CITY OF ALBUQUERQUE

Re: Santa Barbara Multigenerational Center
1825 Edith Blvd. NE
90-Day Temporary Certificate of Occupancy
Transportation Development Final Inspection
Engineer's Stamp dated 05-26-23 (H15-D070)
Certification dated 06-06-24

RE: SBMT Multigenerational Center, 1825 Edith Blvd NE
Traffic Circulation Layout Certification (H15/D070)

SITE PLAN

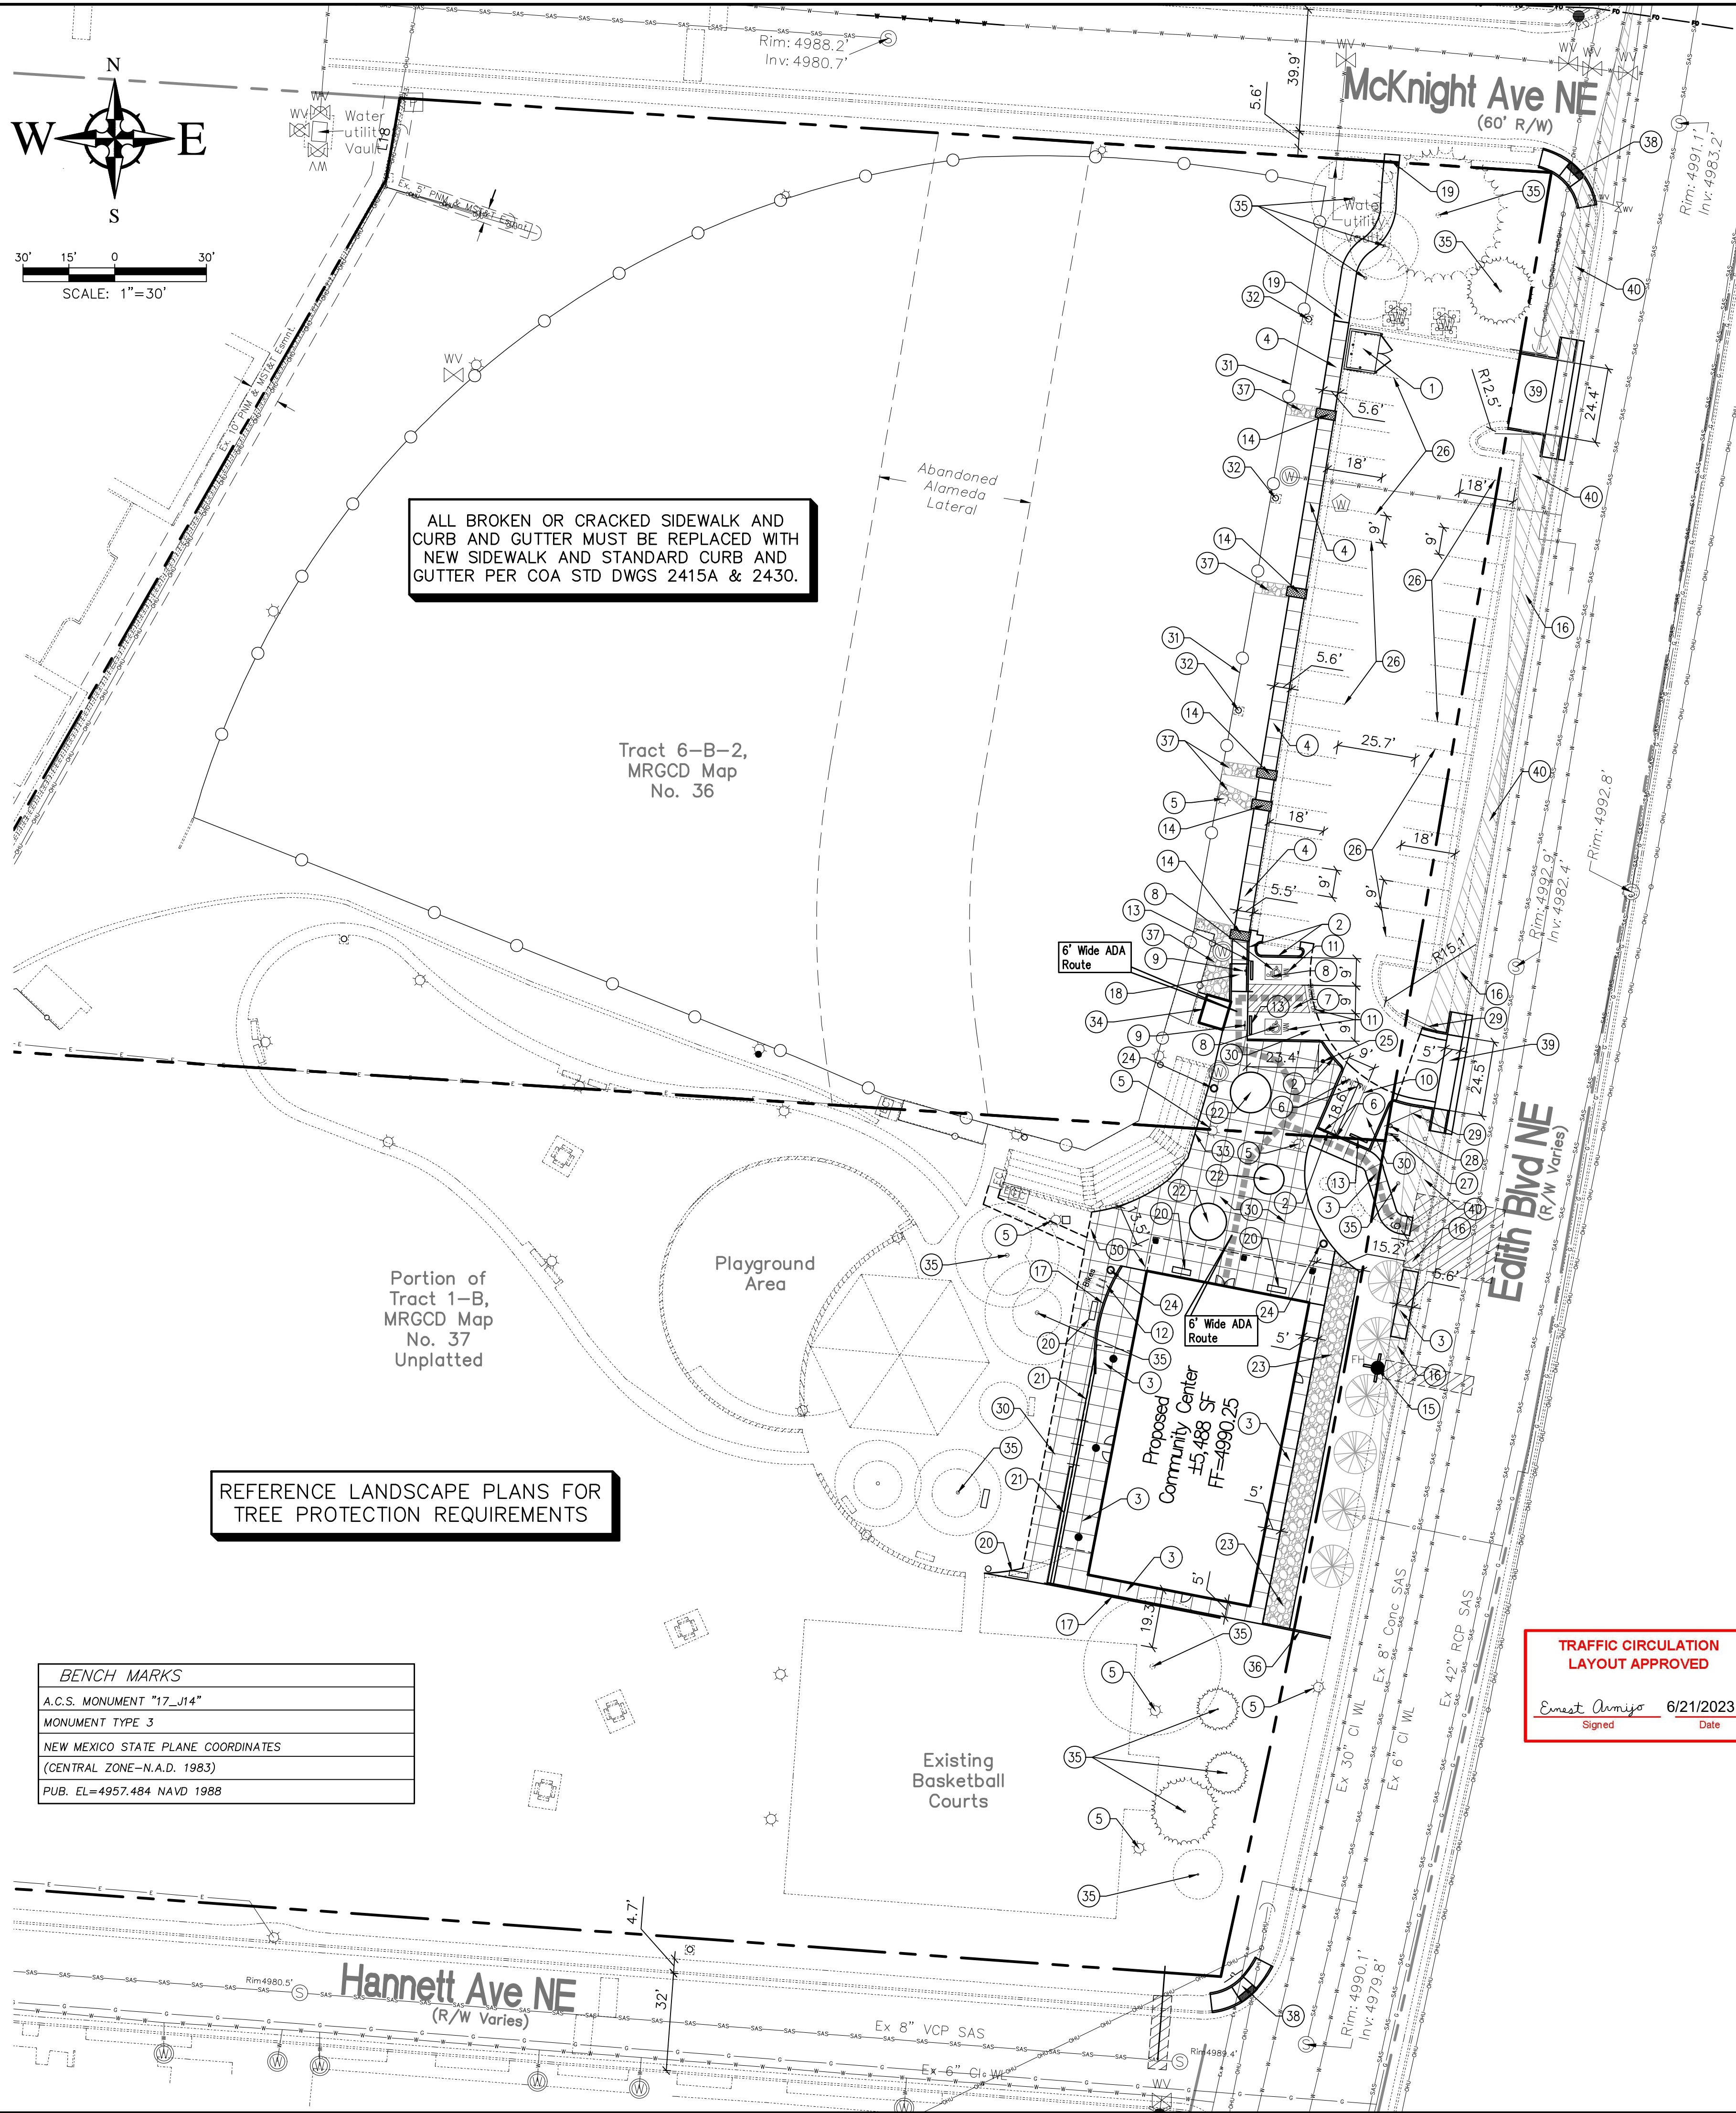
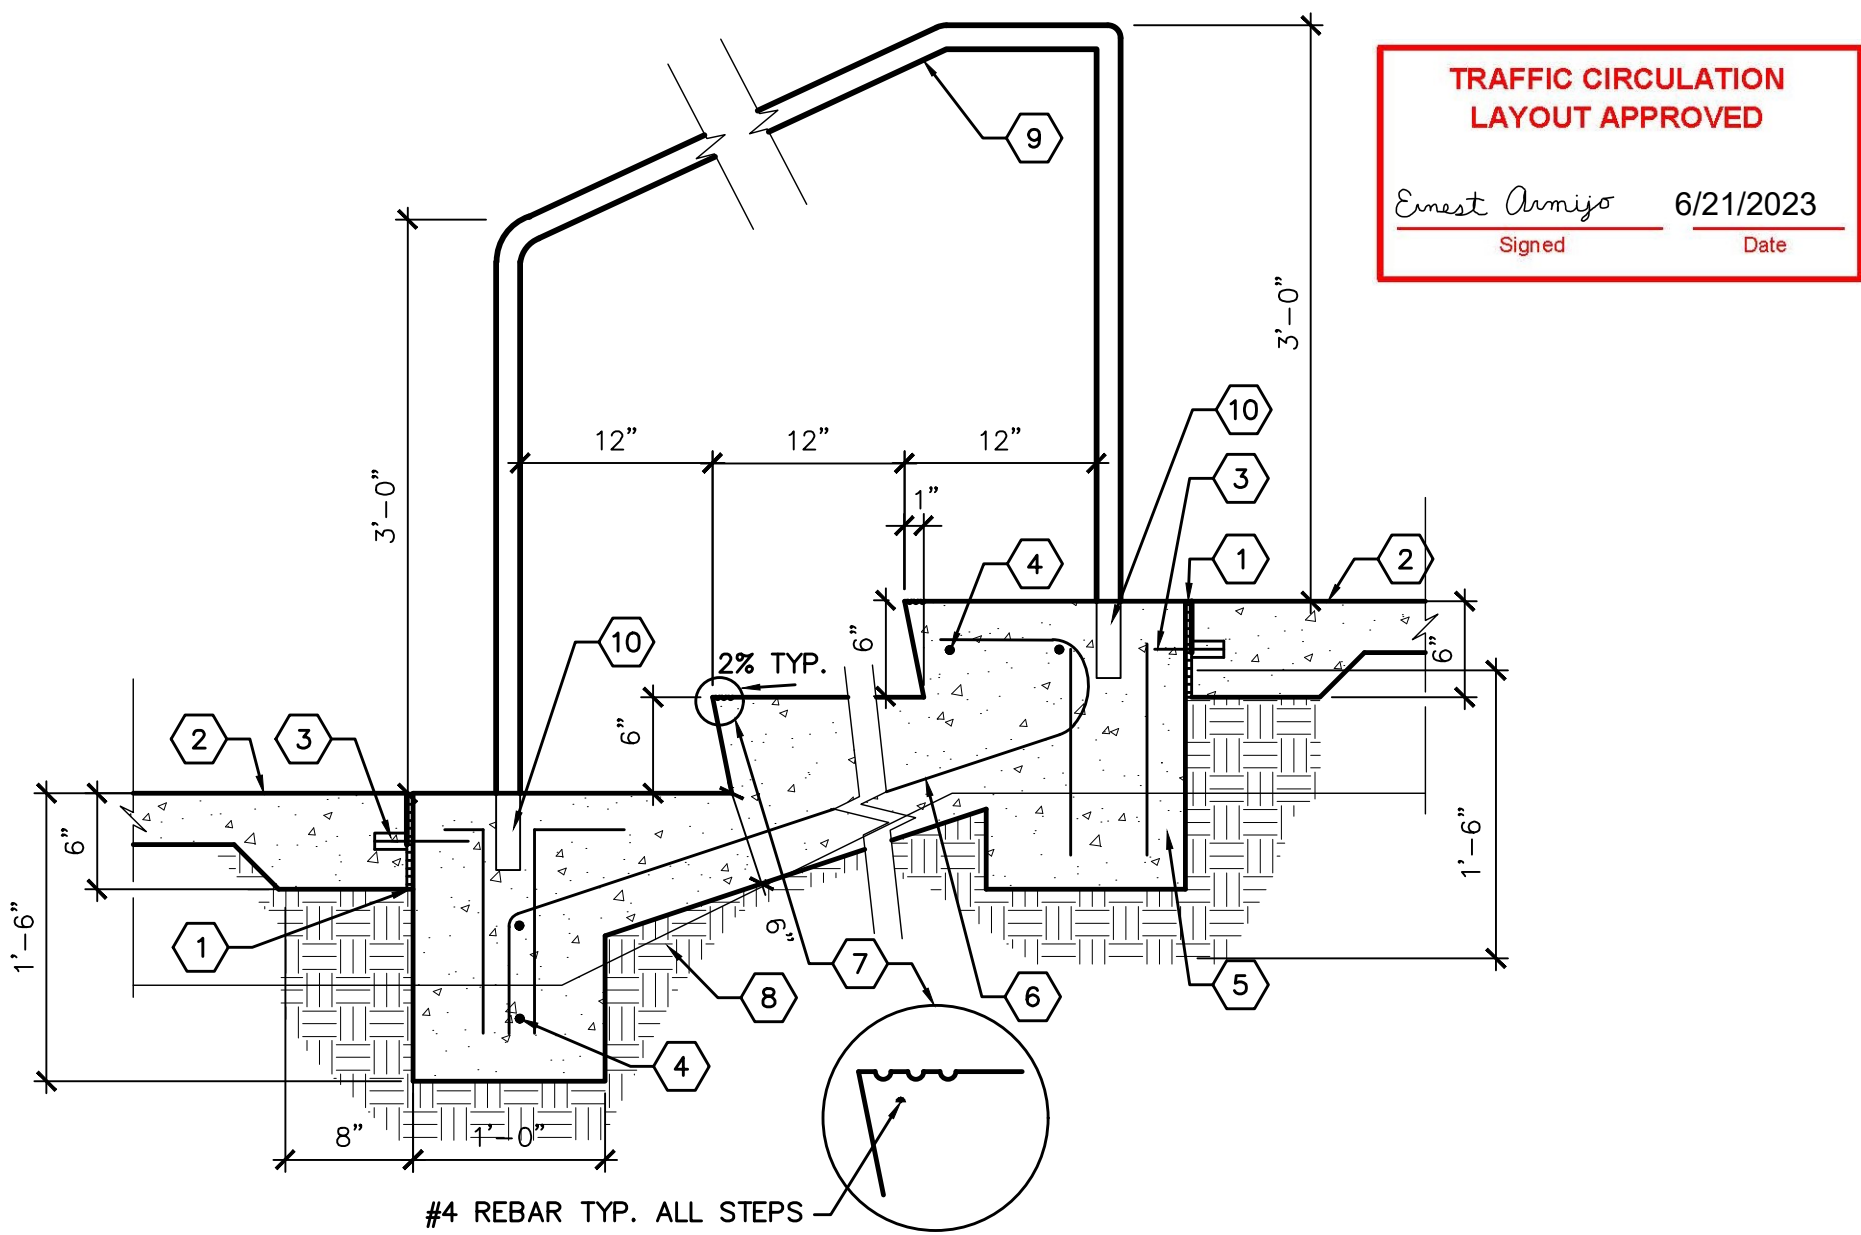
1. Site accesses, parking lot, and the City ROW corner ramps, must be built per city standard as mentioned in the approved site plan.

- The curbs that stick up above grade could be a tripping hazard and need to be painted traffic yellow.
- The ADA route sidewalk slightly exceeds a 5% (1:20) slope and needs to be rebuilt with a 5% maximum slope to keep from needing handrails.
- The parking lot needs to be striped and signage needs to be installed.
- The curb cuts onto Edith Blvd still need to be reconstructed. These curb cuts will need to be built one at a time so that there is continuous access to the parking facilities. Some parking spaces will need to be temporarily blocked off during construction in order to allow for vehicles an area to turn around.
